**Subject: Pottinger Wind Farm – SSD-59235464 – Further Transport RFI**

# Pottinger Wind Farm

Barrier/Cobb Highway Temporary Pullover Bay Options  
30/01/2025 **Update 17/03/2025.**

DRAWN: OM
DATE: 30/01/2025
DWG NO: 768 P01B
SCALE at A3: 1:1000

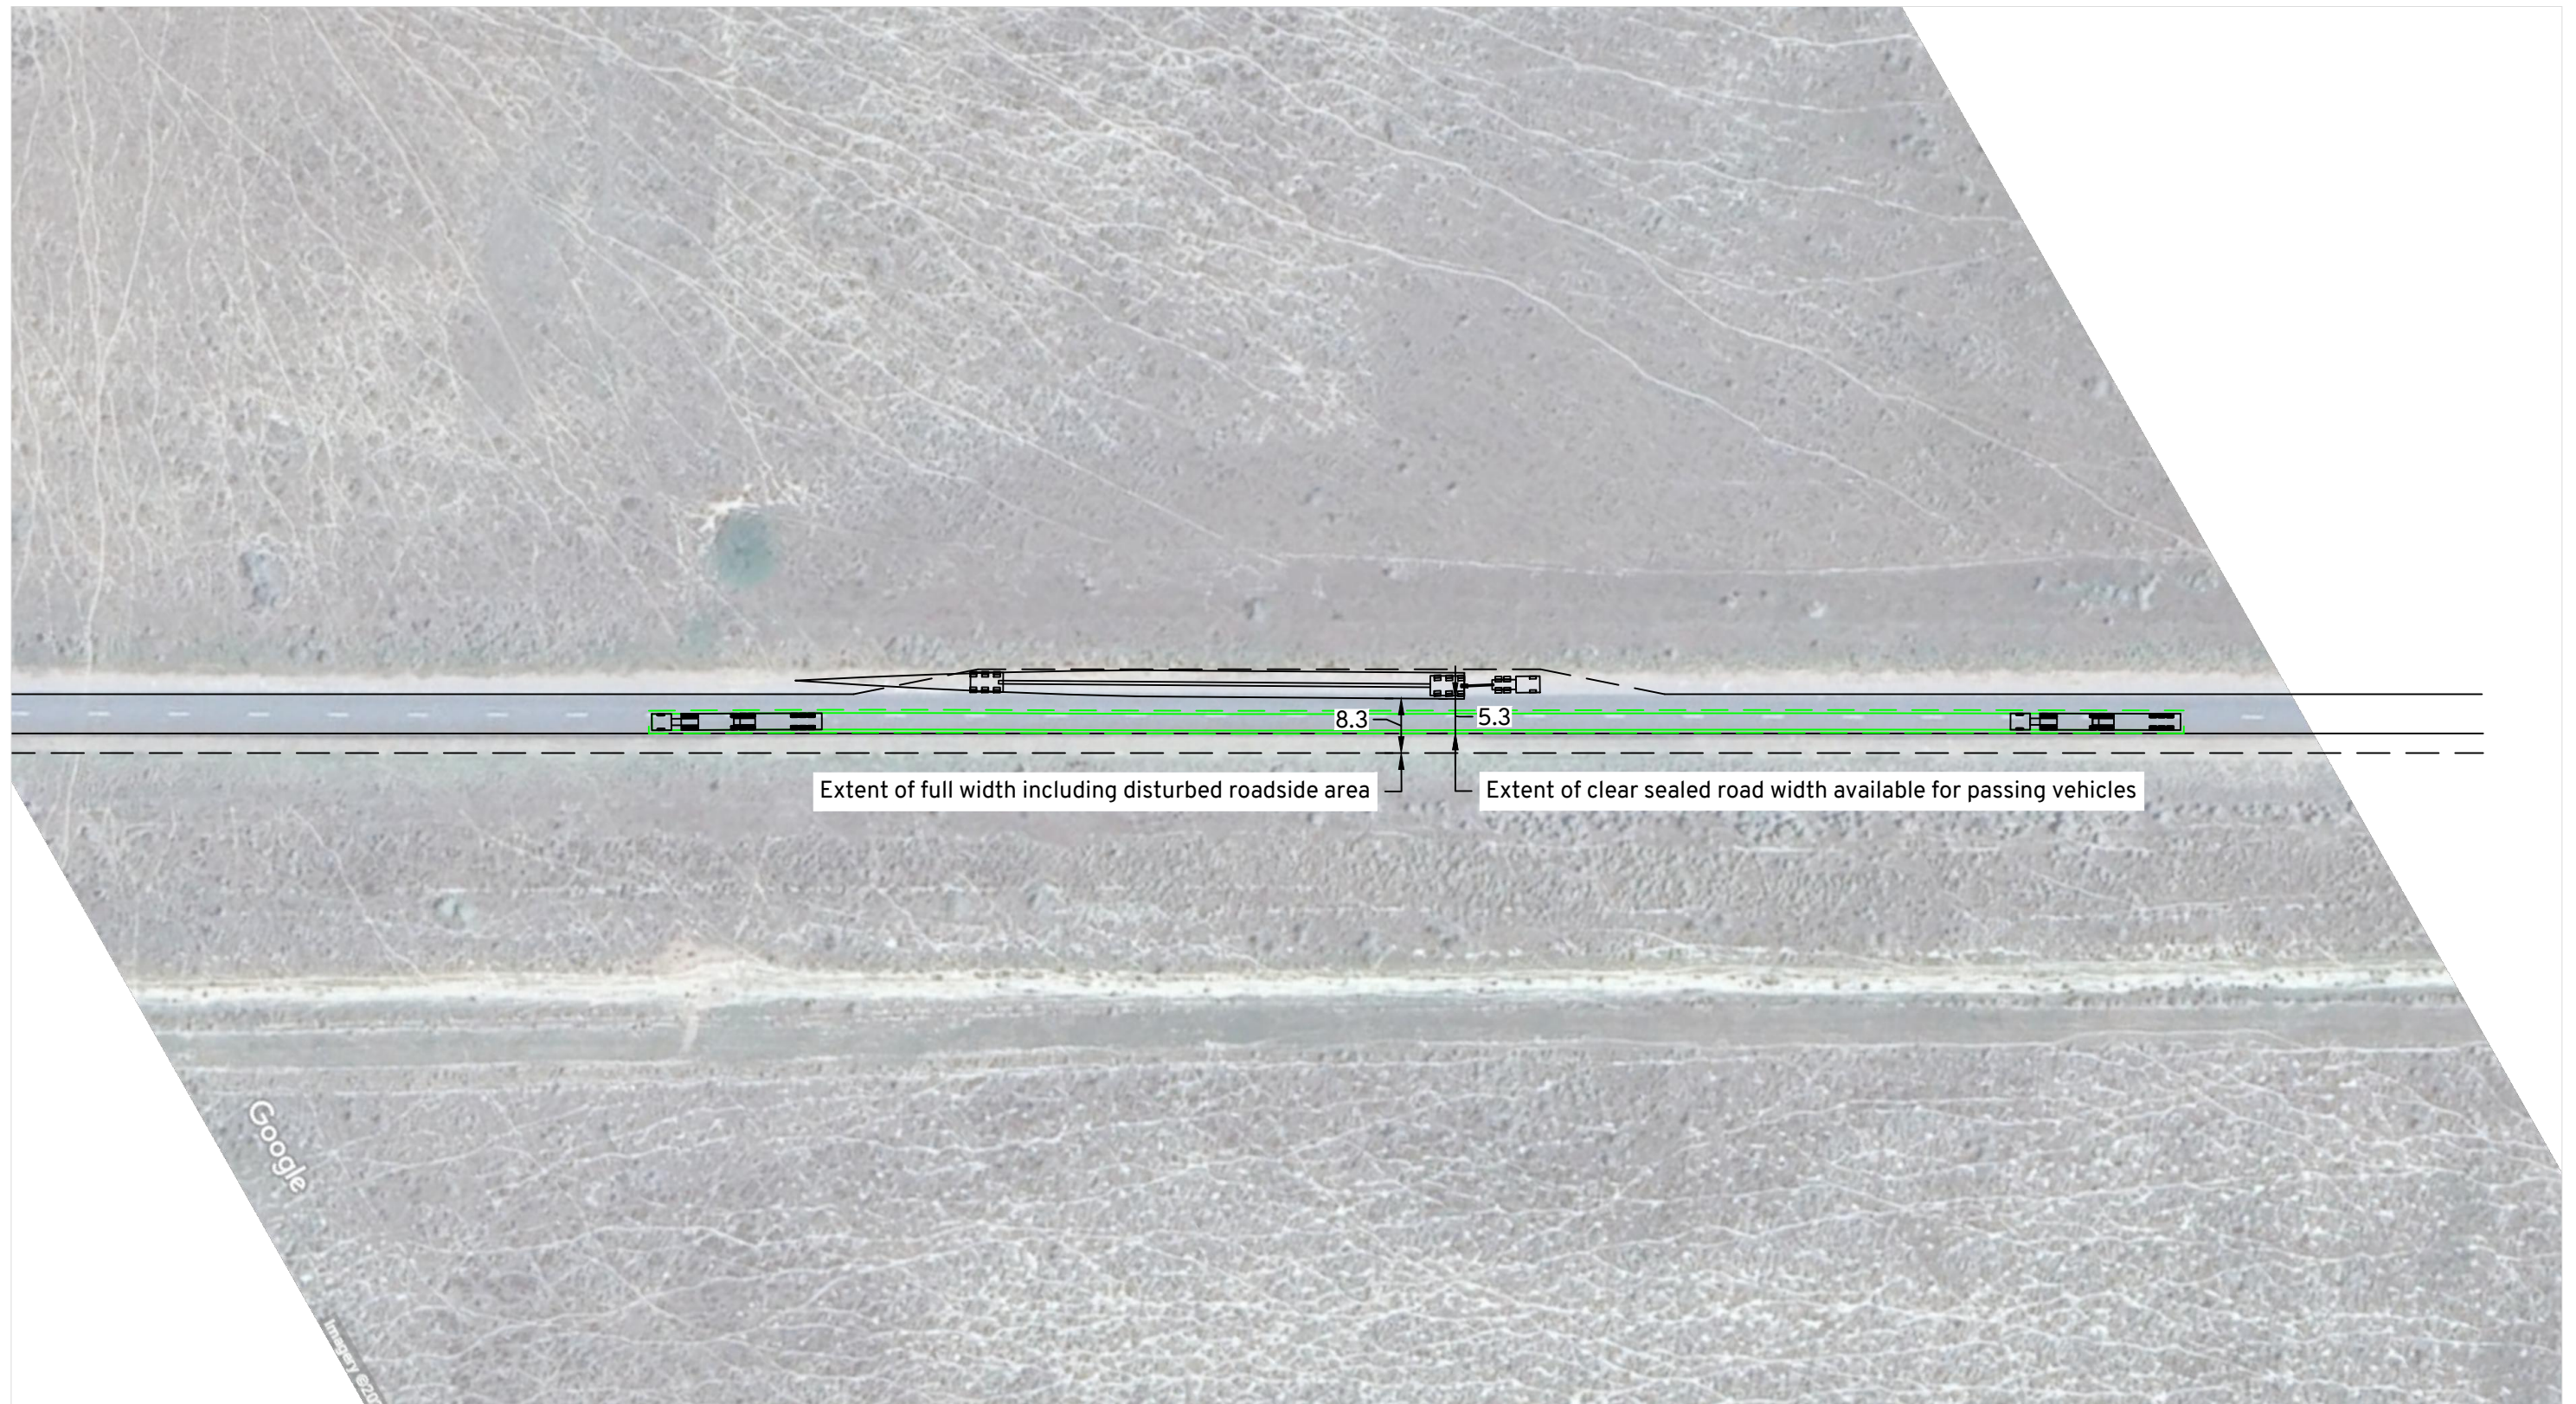
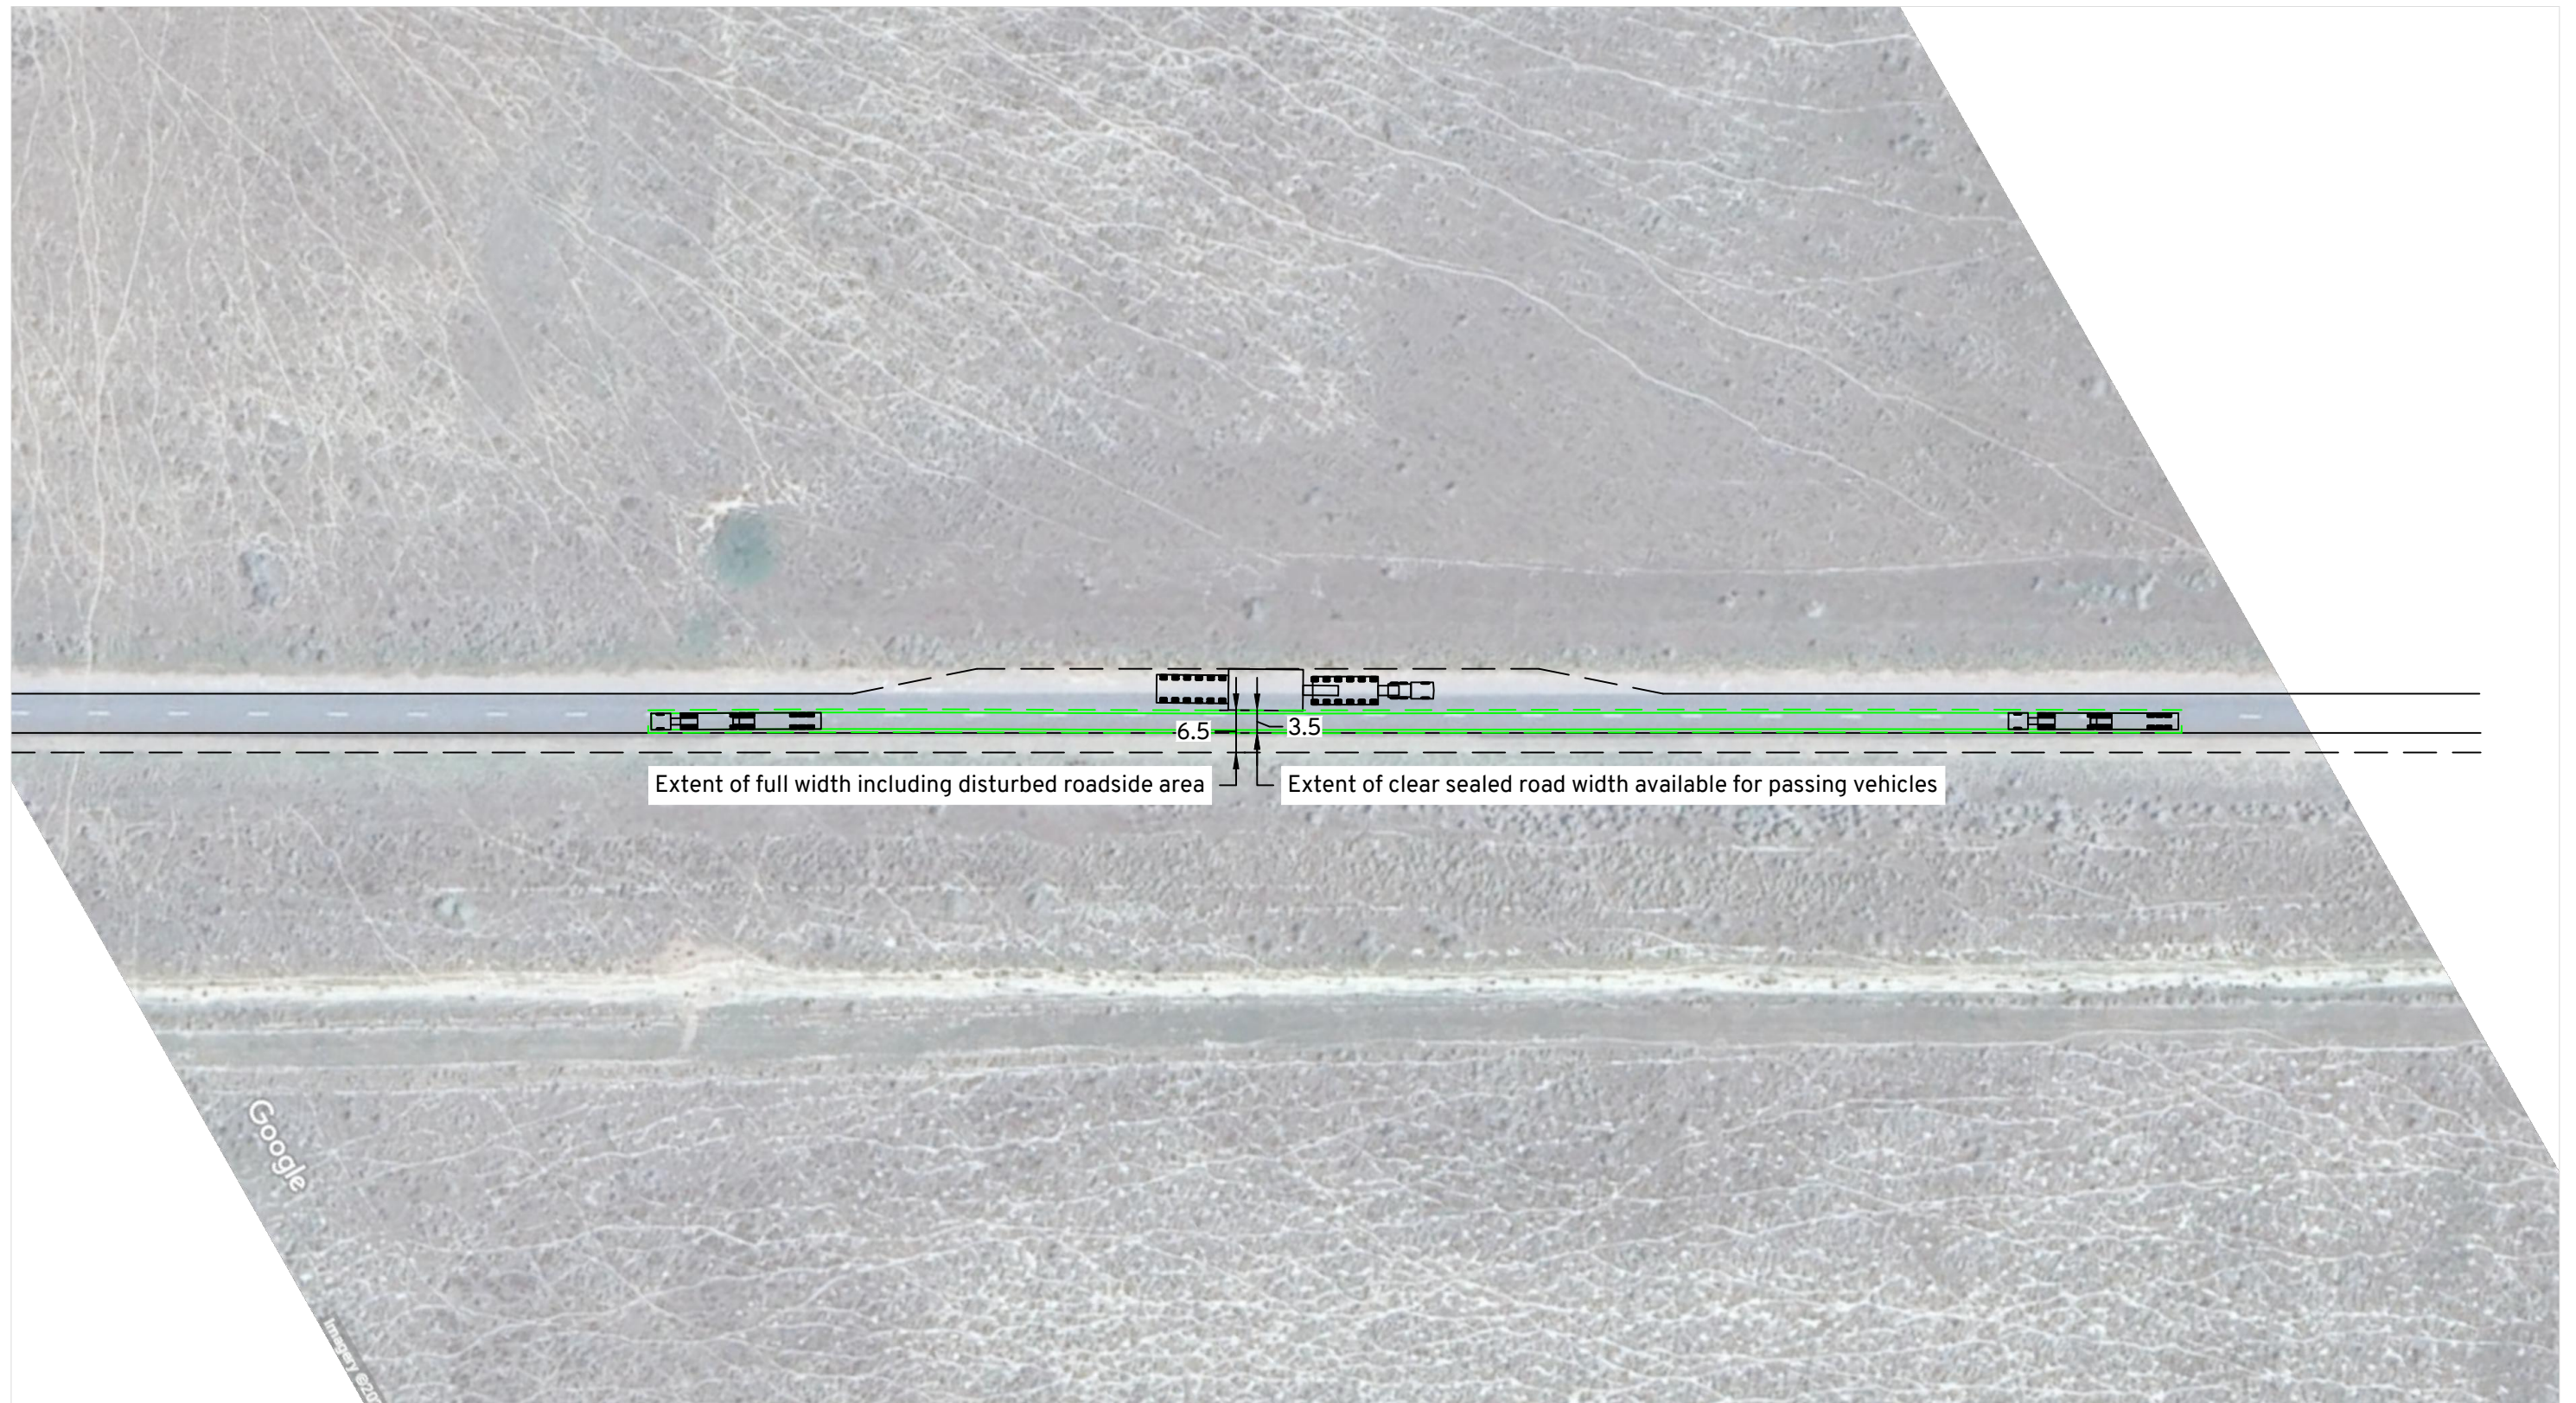
<p>3. The typical OSOM Route Pull Over Bays designs prepared by Amber dated 30 January 2025 (DWG No. 768 P01B) within Appendix G submitted as a part of the Someva additional information package on 5 February 2025, identifies the high-risk OSOMs for towers and blades positioned when stopped partially within the through lane. This design prevents oncoming and following vehicles from passing the high-risk OSOM movements when stopped within the pullover bay without crossing into the incorrect lane. The typical strategic concept designs for the pullover bays for all</p>	<p>The current concept design provides a high-level strategic concept to demonstrate feasibility at an arbitrary location. Further refinement of OSOM vehicles within pullover bays will be undertaken post-approval as part of detailed design, in consultation with TfNSW and based on the final number of turbines, type of turbine and associated final transport OSOM types and volumes.</p> <p>Further advice in consultation with Amber: It is not the intention that the OSOM vehicles are required to pull completely off the road at all temporary pull over areas. Some locations are expected to provide sufficient roadside width for the OSOM vehicles to pull over fully off the road and allow clear two-way access. However, it is not considered feasible or necessary to provide 6.5m of clear width on a single side of the road at all locations. Instead, any vehicles travelling behind the load would be able to pass safely using the opposing travel lane which would be facilitated through the</p>

Agency comment	Response
locations are to be revised to demonstrate that the high-risk OSOM vehicles are contained within the pullover bays.	police escort vehicles. All vehicles would be required to pass at 40km/h given the police escort vehicle would operate with flashing blue and red lights. The time taken for vehicles to pass the load using the oncoming lane would be a matter of seconds based on the proposed transport configuration lengths. Peak hourly traffic volumes along the route are generally expected to be up to approximately 80 vehicles per hour (two-way total) in the worst-case scenario as outlined in the memo, which would provide ample opportunities for vehicles to pass using the oncoming lane without resulting in any notable delays or safety concerns.
